CITY OF ALBUQUERQUE

**RE: 9808 Central Ave.
Grading and Drainage Plan
Engineer's Stamp Date 3-4-2016 (File: L20D024)**

From: Abiel X. Carrillo
Sent: Tuesday, February 16, 2016 9:06 AM
To: 'tgcengineering@aol.com'
Cc: Biazar, Shahab; Cherne, Curtis
Subject: L20D024 - 9808 Central - Stamp Date: 2/1/2016

SHEET NO. C1

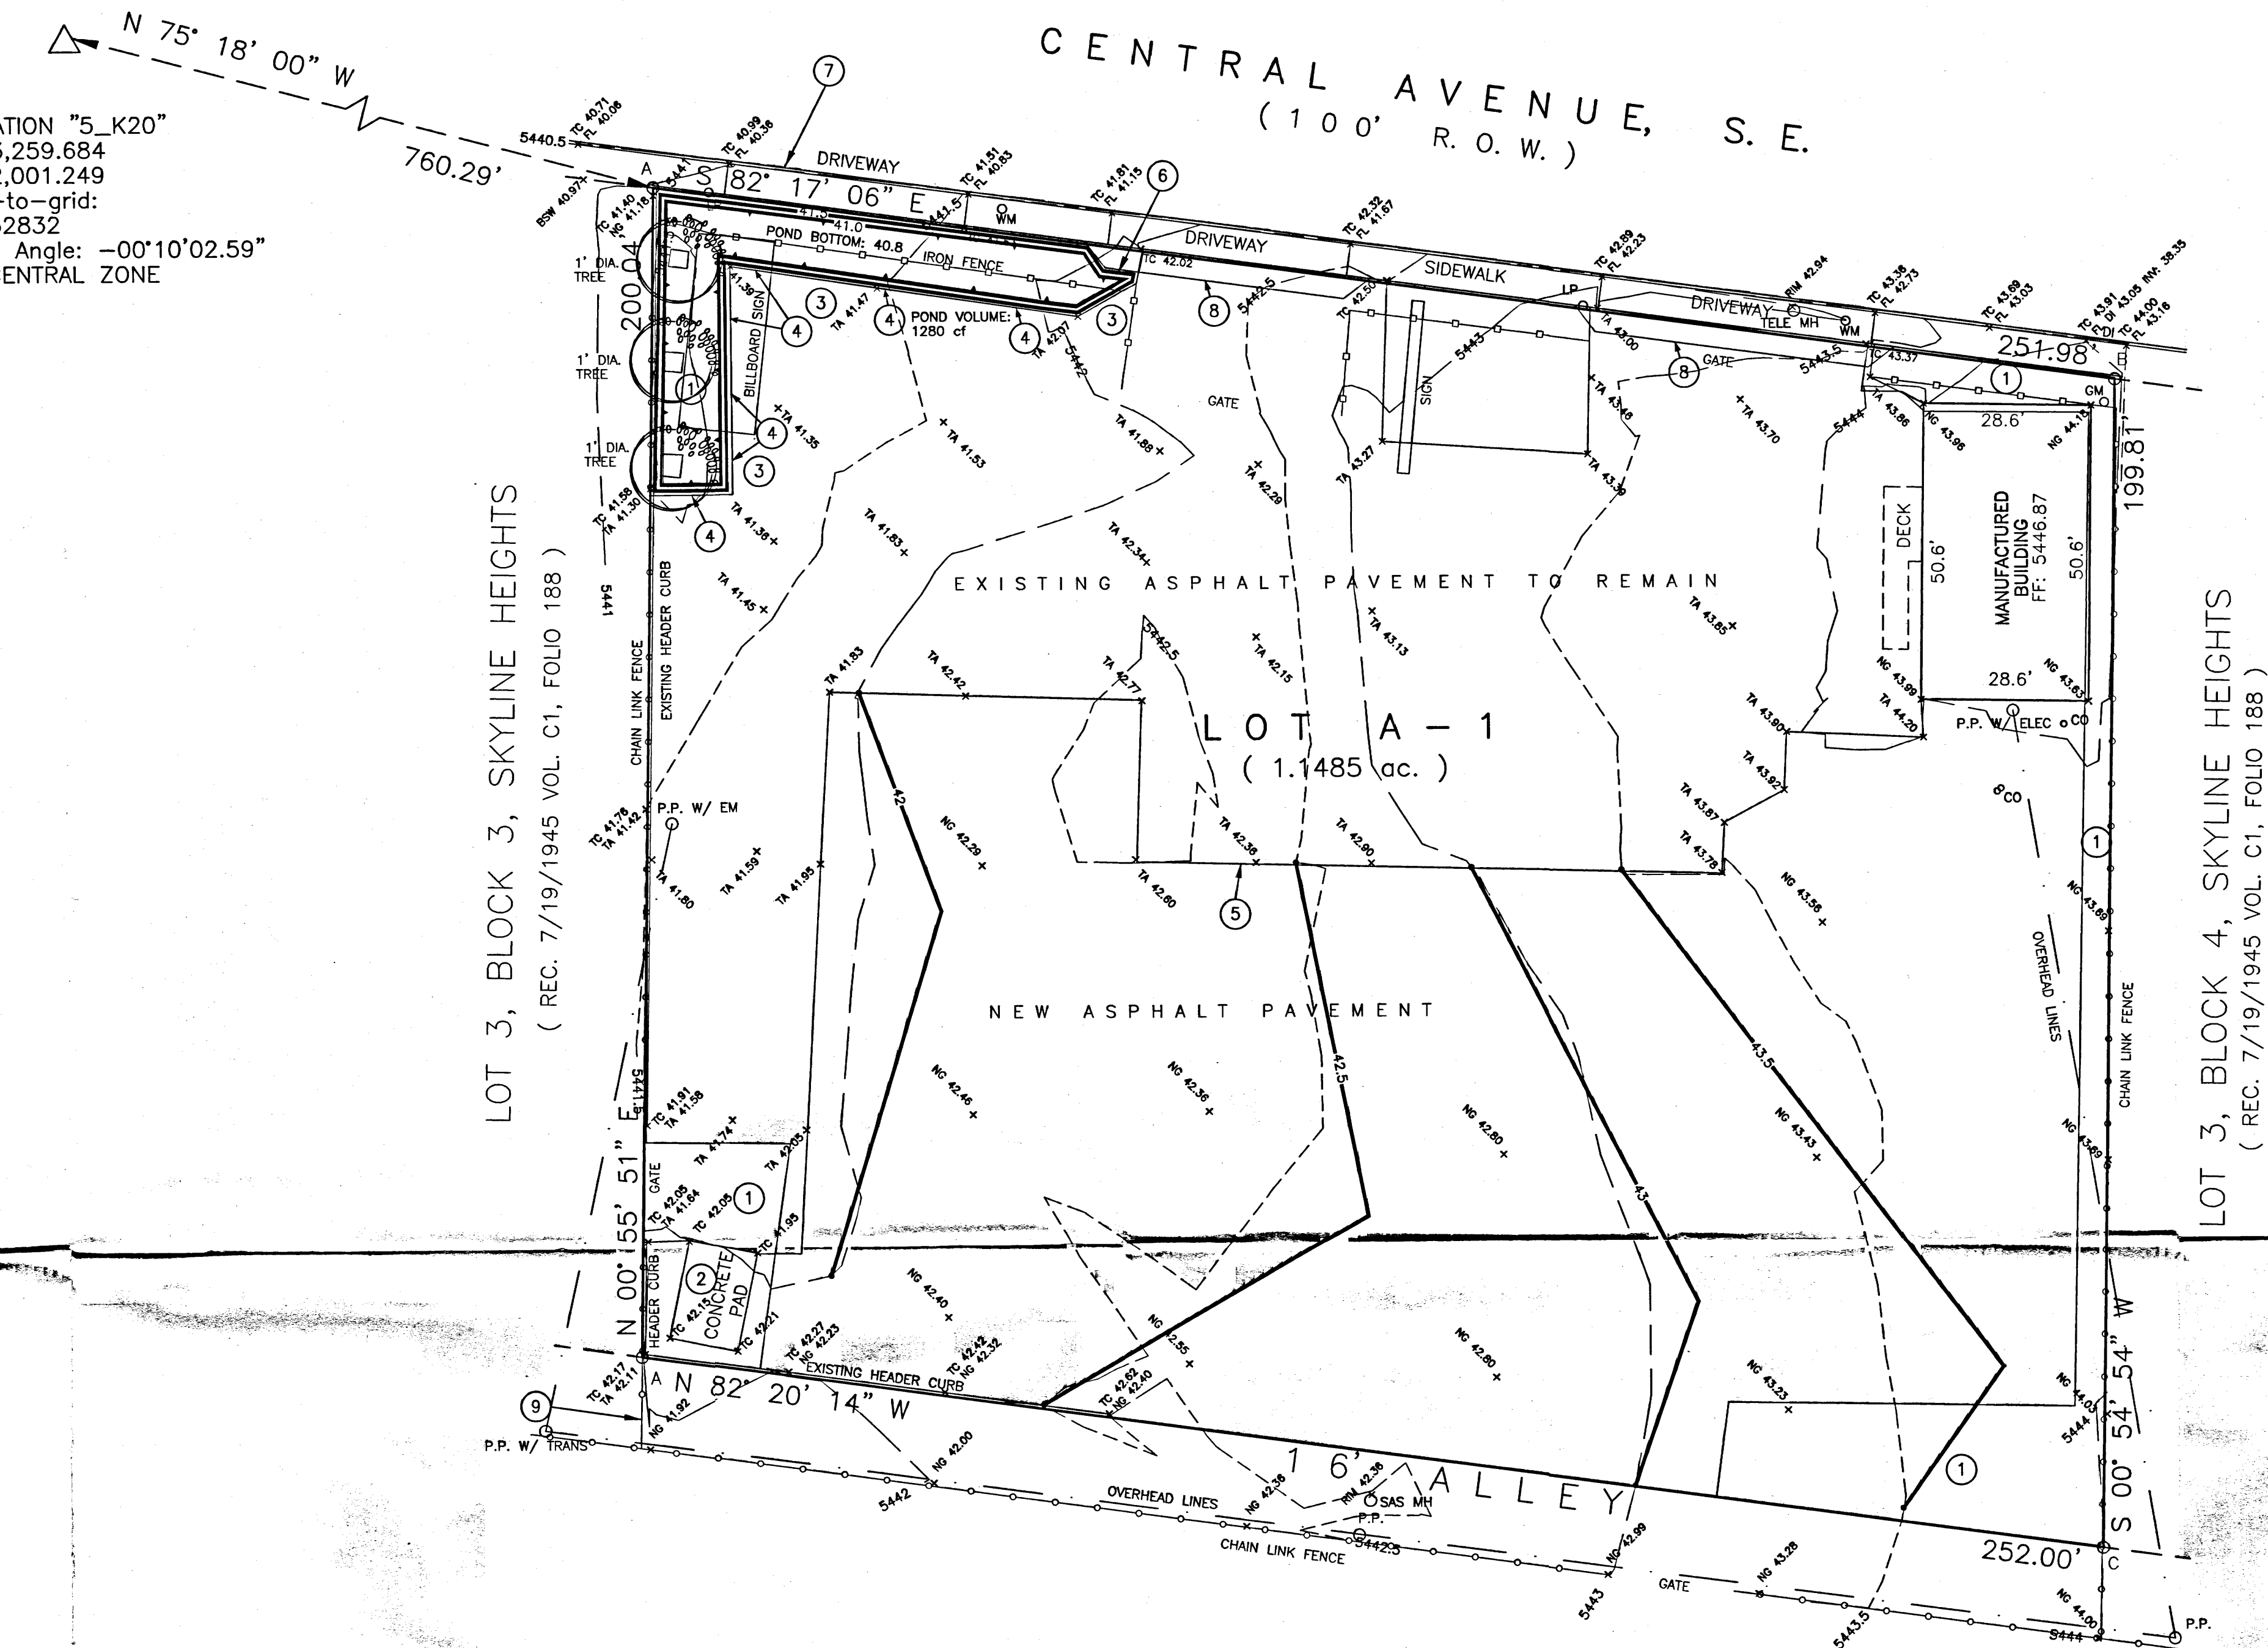
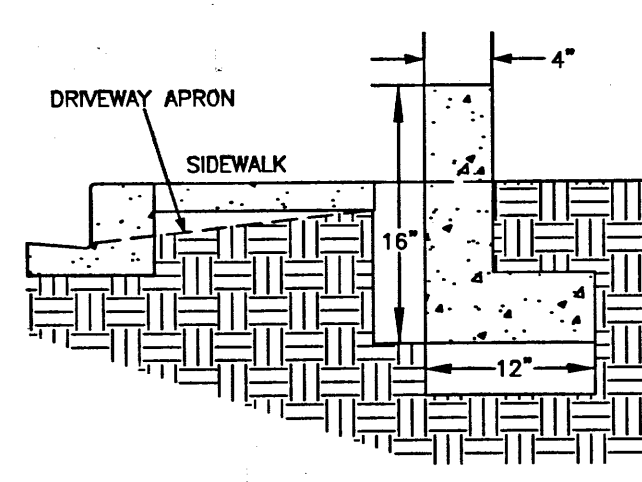
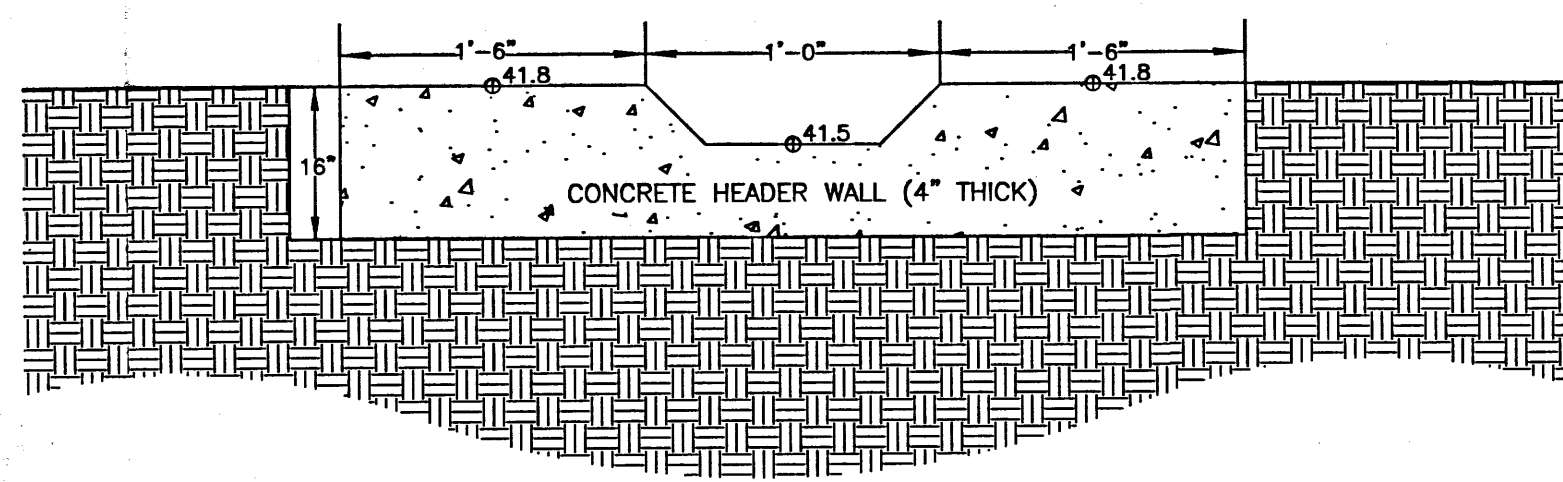
Based upon the information provided in your submittal received 3-4-2016, the above referenced Grading and Drainage Plan is approved for Grading Permit and Paving Permit. Our previous comment letter mentioned the need for a SO-19 Permit, but that was triggered by the sidewalk culvert which is no longer a part of the design, so it is no longer needed. No need to resubmit, you may just cross out the note that references the permit.

SHEET NO. C1

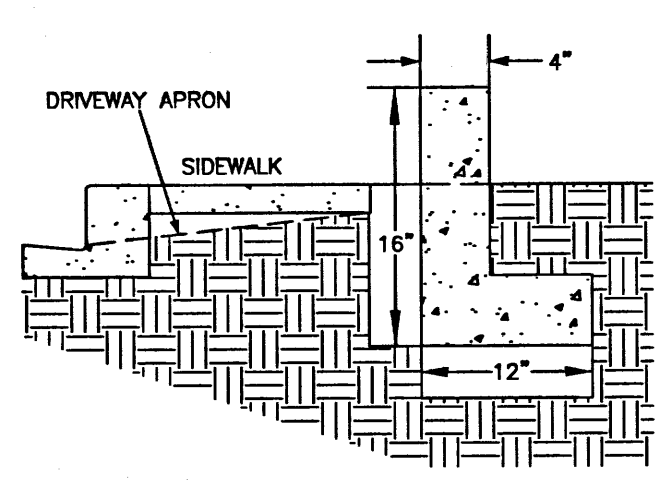
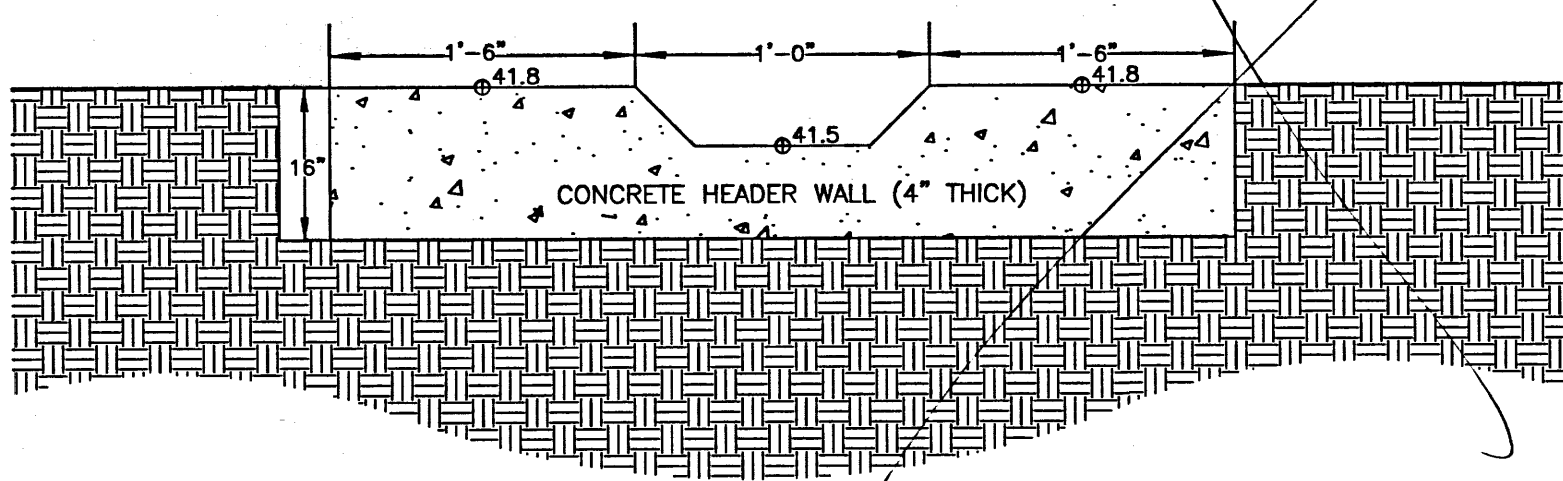
1. The existing fencing at the rear of the lot is encroaching on the 16-foot public alley. The alley needs to be cleared, and the fencing needs to be re-set at the property line. ✓ *Compromise is to open the west side for access*

2. The westernmost driveway on Central Ave, which appears to be obsolete, needs to be removed. ✓
3. The spillway from the first flush pond to Central Ave needs to be routed through a sidewalk culvert. *Routed to the driveway instead*

4. One of the Notices to Contractor mentions the need for a SWPPP since the site is over 1-acre. The size of the property is approx. 1.1 acres. However, about half of the asphalt is proposed to remain undisturbed, which may lower the actual area of *disturbance* to less than an acre. Please review. Furthermore, if the project site (area of disturbance) is in fact over an acre, an Erosion and Sediment Control Plan will need to be approved by the City's Stormwater Quality Engineer prior to Hydrology's approval for Building Permit. For questions regarding the ESC Permit you may contact Curtis Cherne, ccherne@cabq.gov, or 924-3420. ✓

5. One of the Notices to Contractor mentions that any work in the City Right of Way will require a Work Order. However, if the only work on Central is to construct the sidewalk culvert and remove the driveway, then a SO-19 Permit (which does not require a set of Work Order drawings) can be used. ✓

6. Minor comment: the legend shows contour lines @ 1-foot intervals, but they appear to be ½-foot contours on the plan. ✓
